**Subject:** RE: FAO James Evans re planning application no. 2026/62/91894/W

I am a local resident writing to formally alert you to significant, material inaccuracies in the submitted plans for application 2026/62/91894/W at 7 Little Croft Close Holmfirth HD92BD

AS EXISTING_ ELEVATIONS

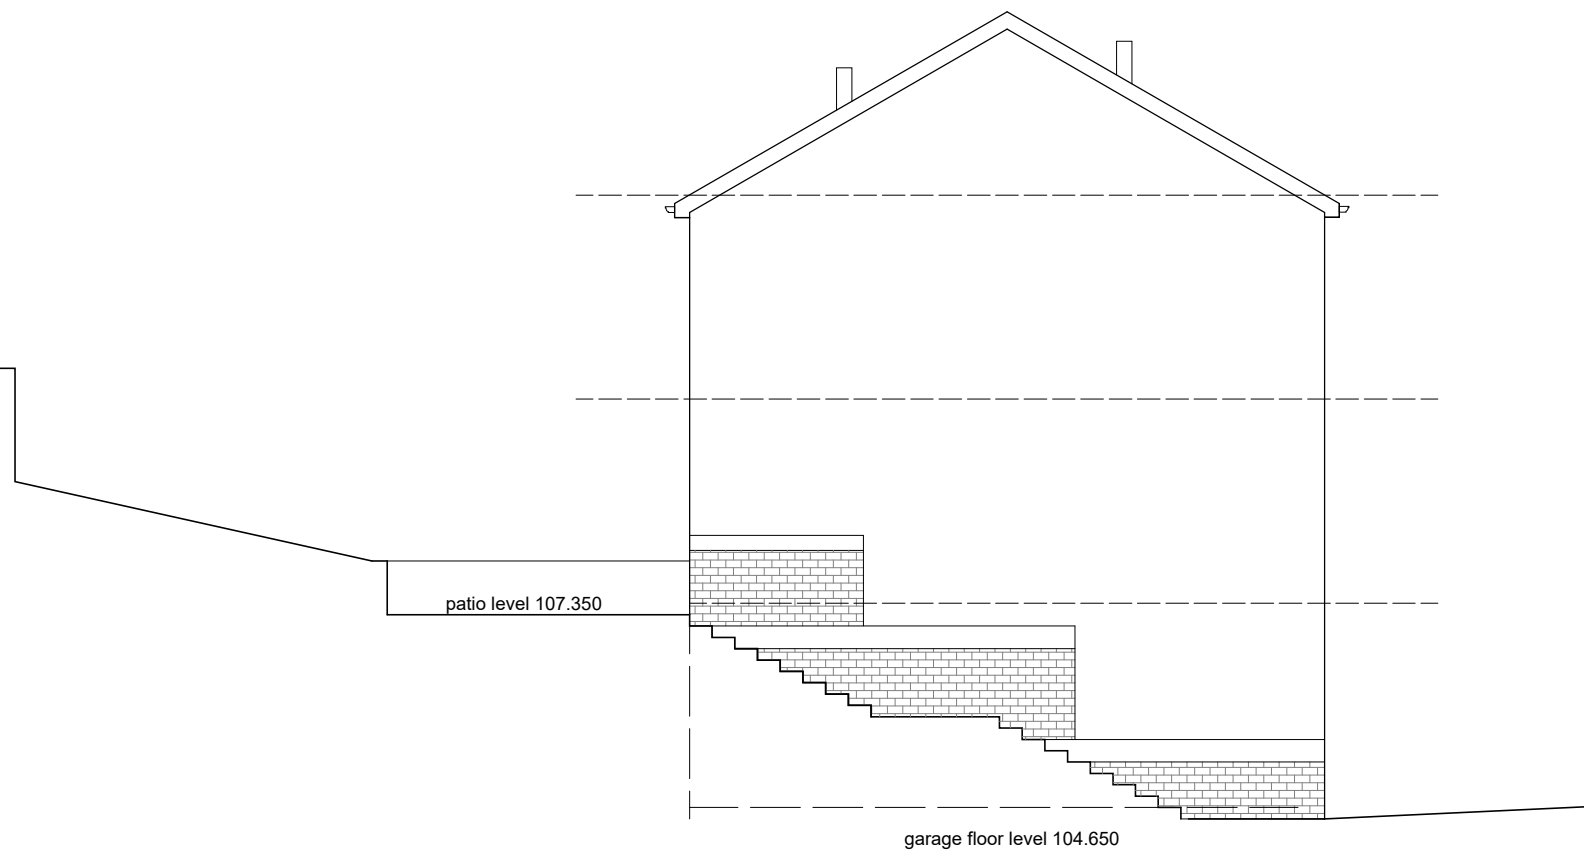
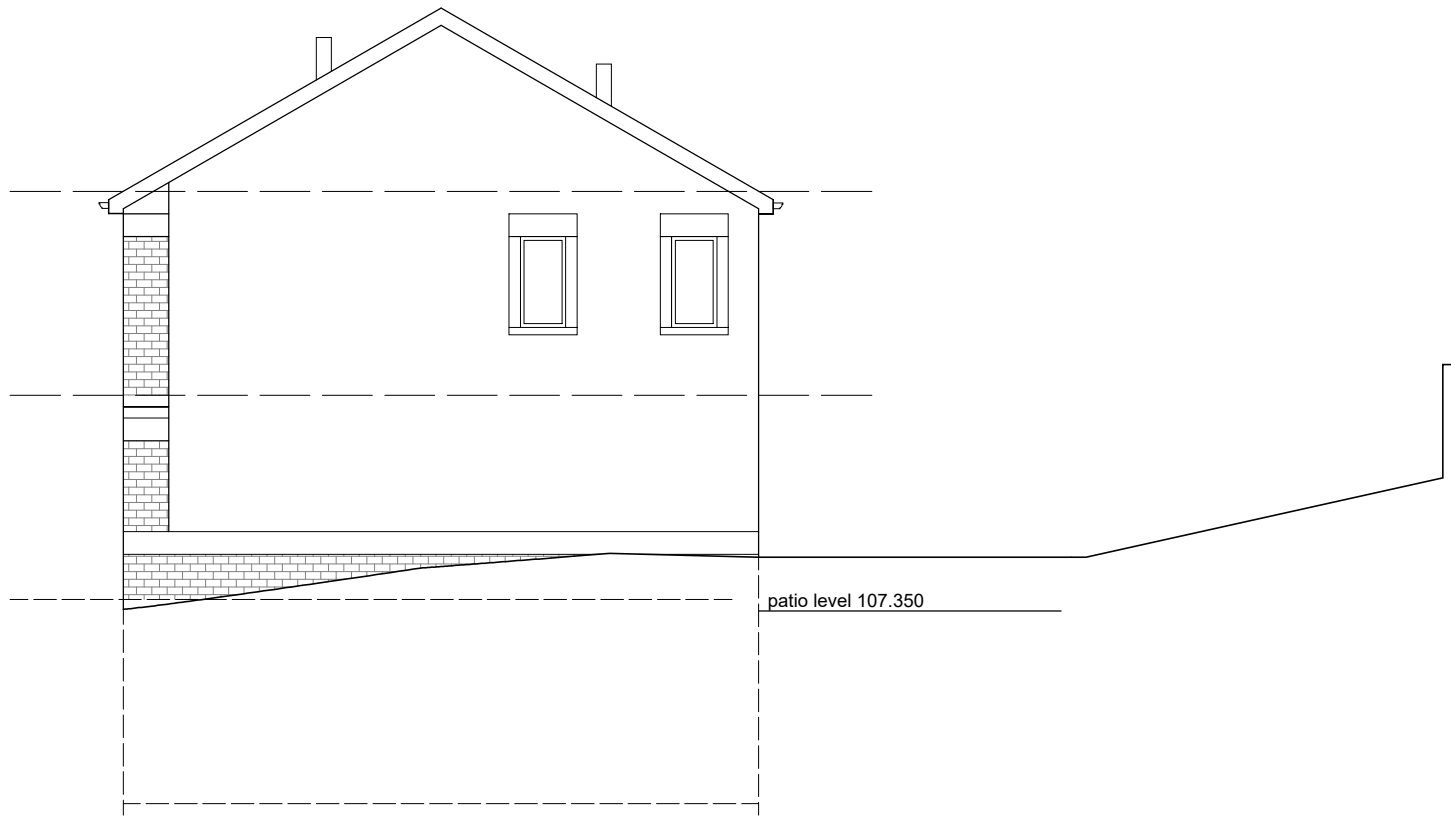
The existing site plans and elevation drawings submitted by the applicant are fundamentally incorrect. They completely omit an existing loft conversion on the property, which contains two additional bedrooms and roof windows which has been carried out since the original property was completed in July 2025 in what would appear to be a breach of the original planning consent for the development.

Because the drawings show an outdated three story property rather than the actual four-story reality, the council cannot accurately assess:

1. **Scale and massing:** The intensity of use and true scale of the building are being hidden.

Thank you for your email, I will get in touch with the agent to clarify the situation with the loft conversion. If they confirm this is already in place the application description will have to be changed and new plans will have to be submitted.

AS EXISTING_ FLOOR PLANS

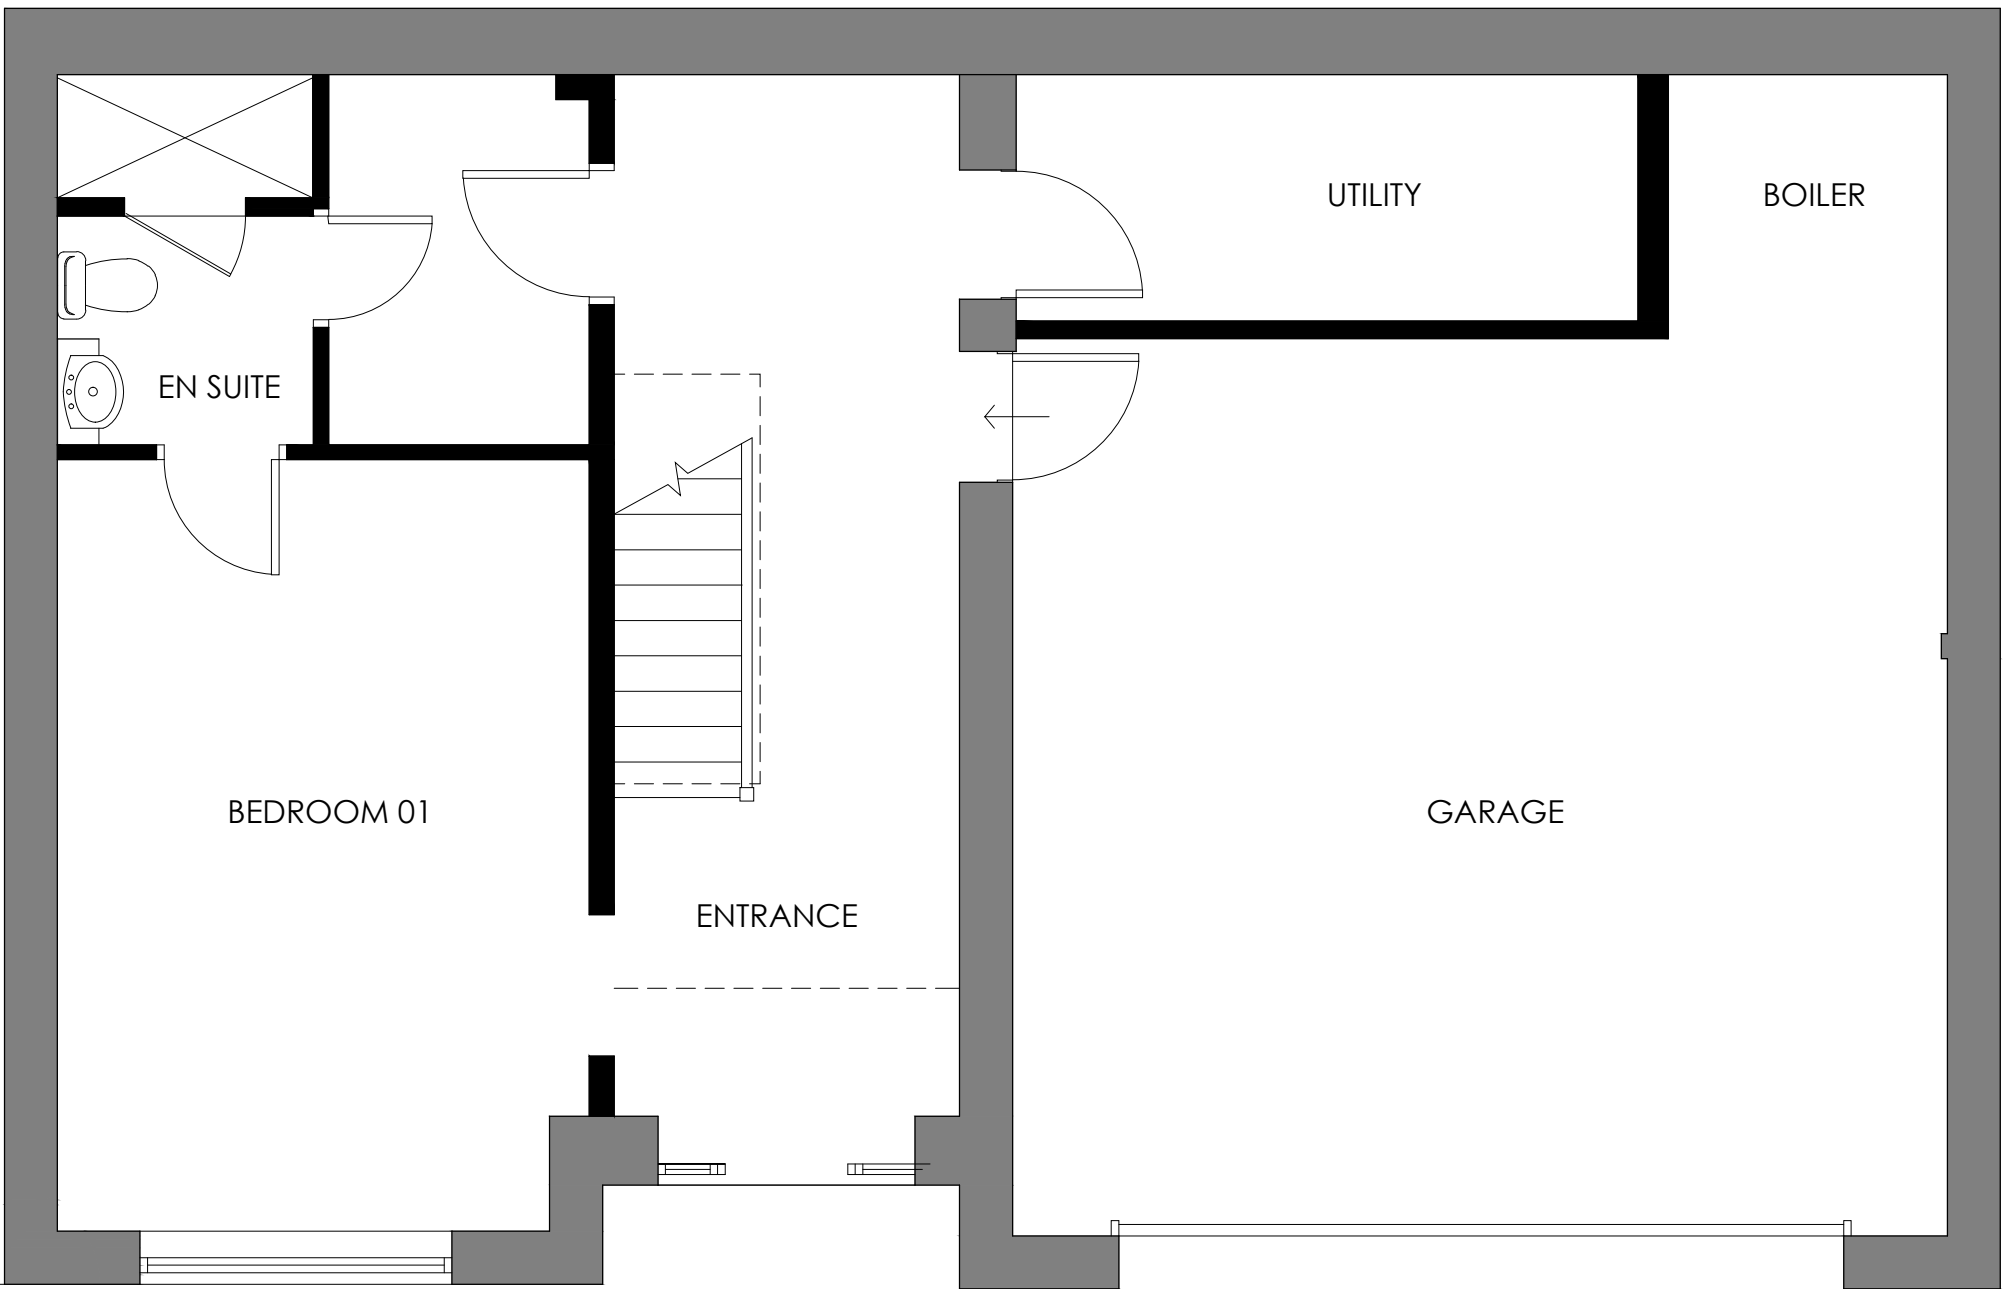
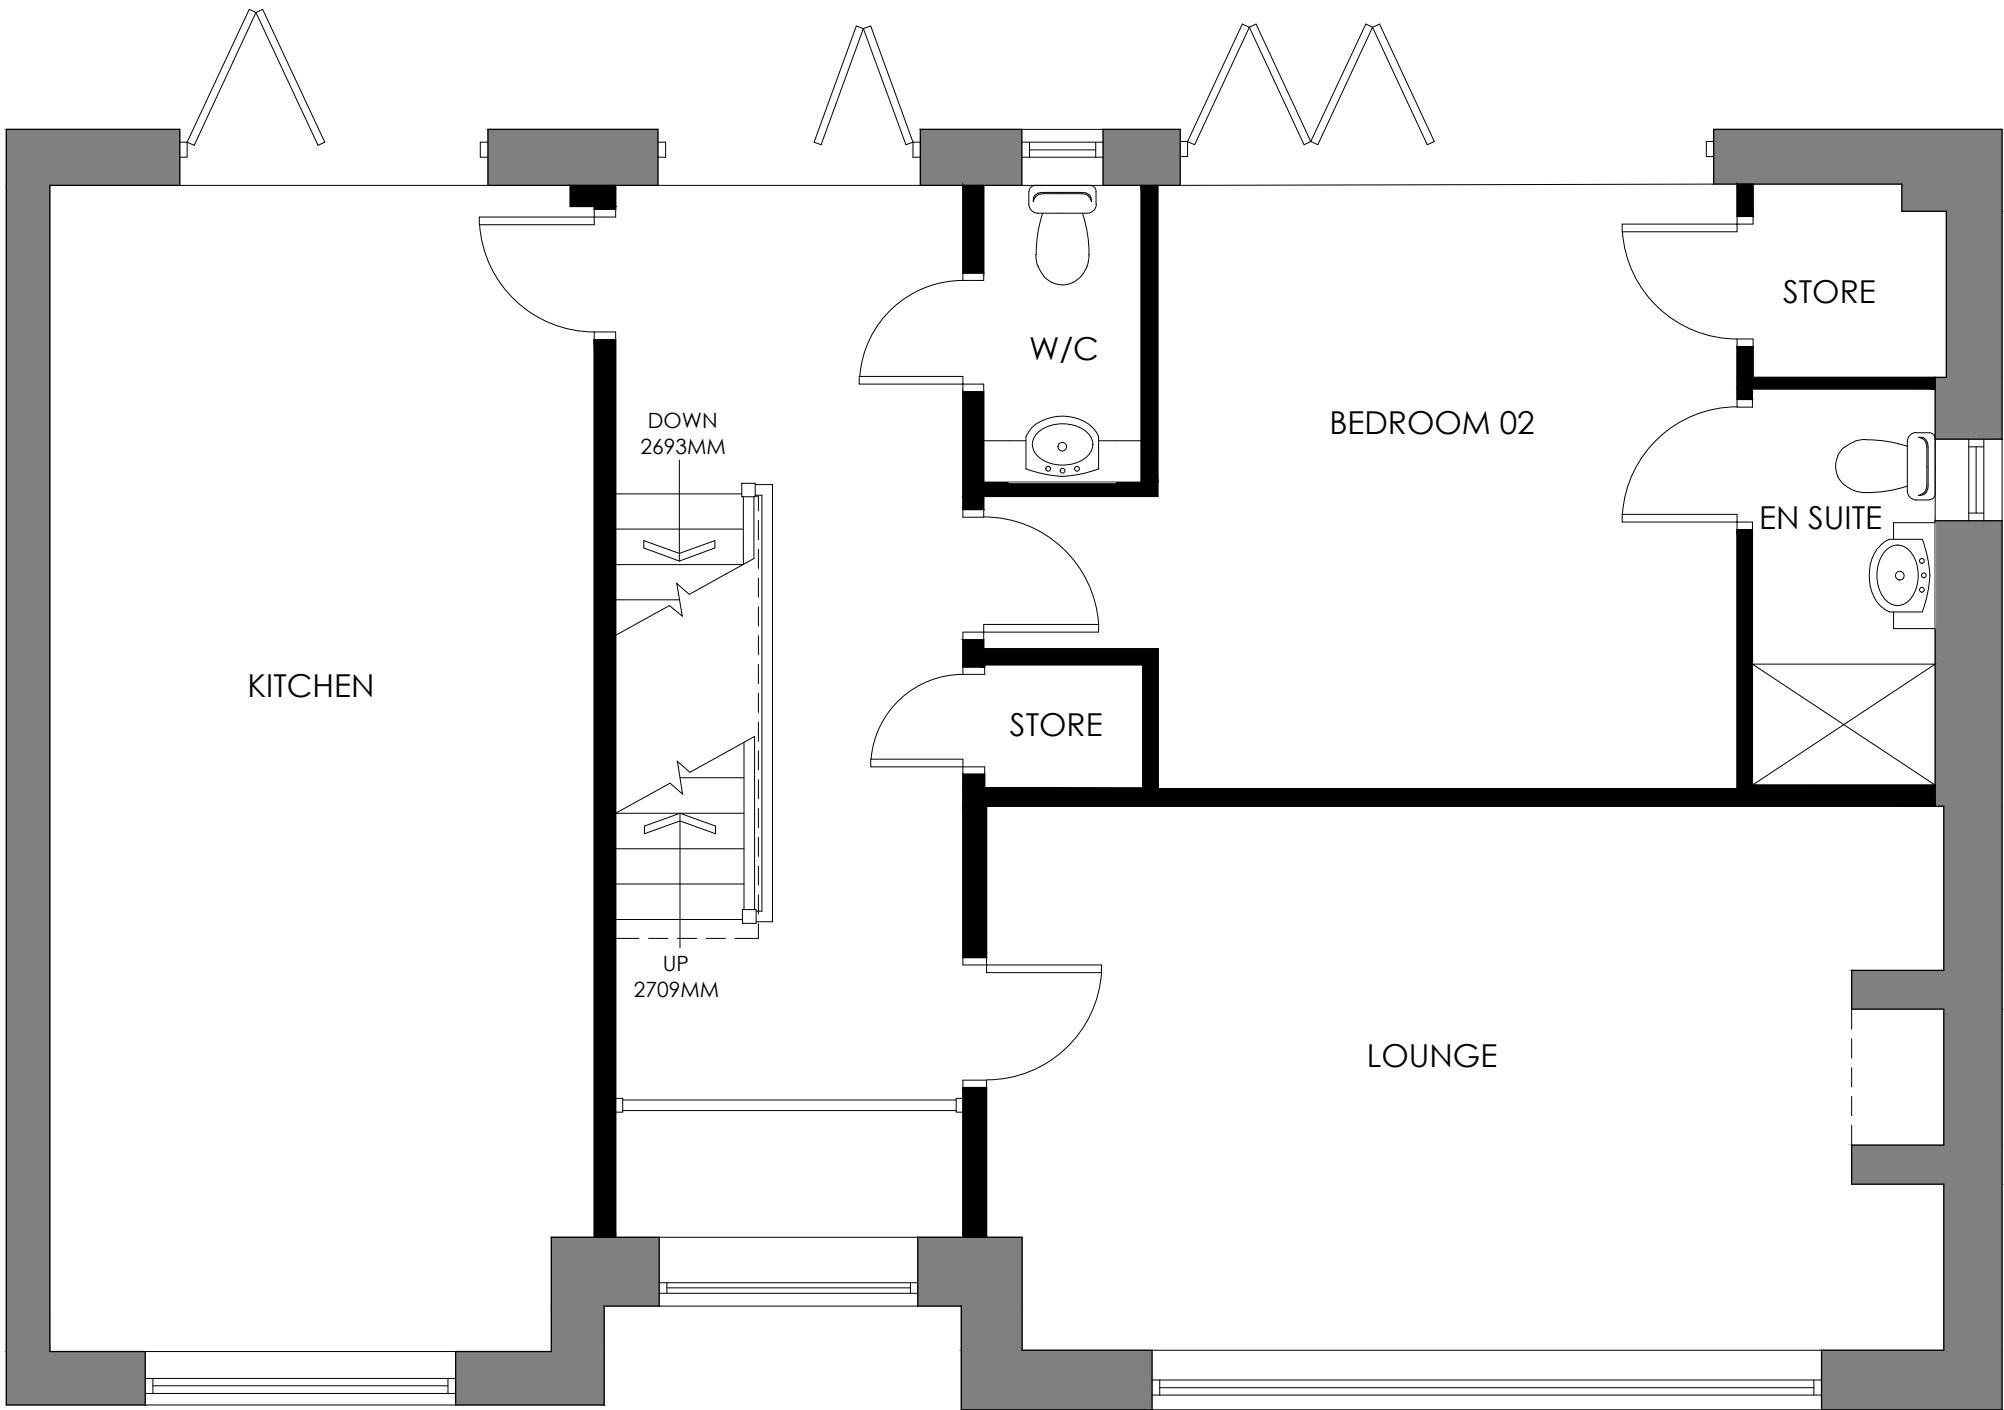
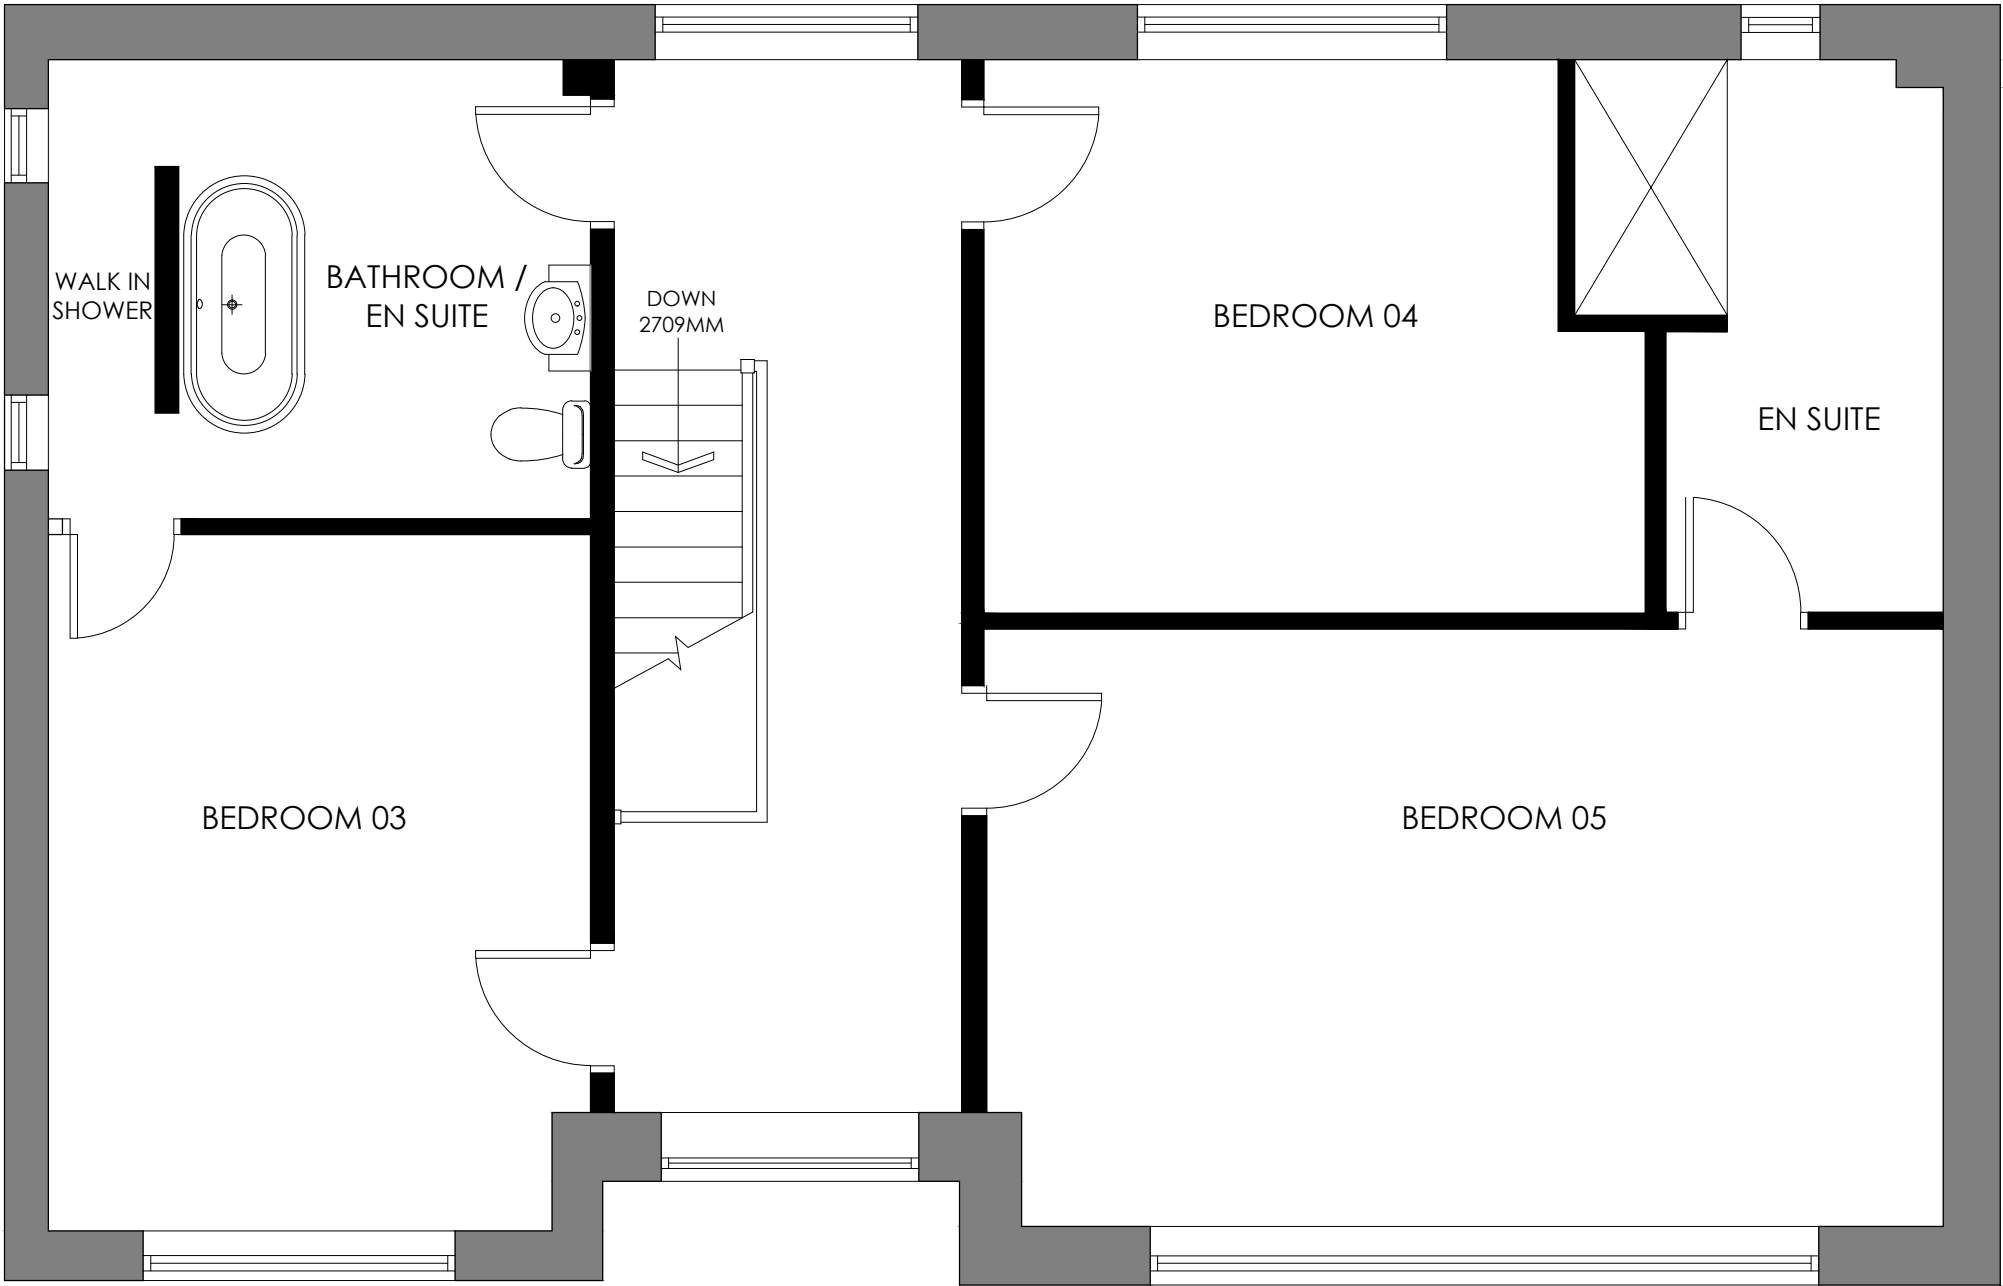
2. **Parking requirements:** The baseline bedroom count is incorrect as the property is now a seven bedroom property understating local parking impact and traffic flow.
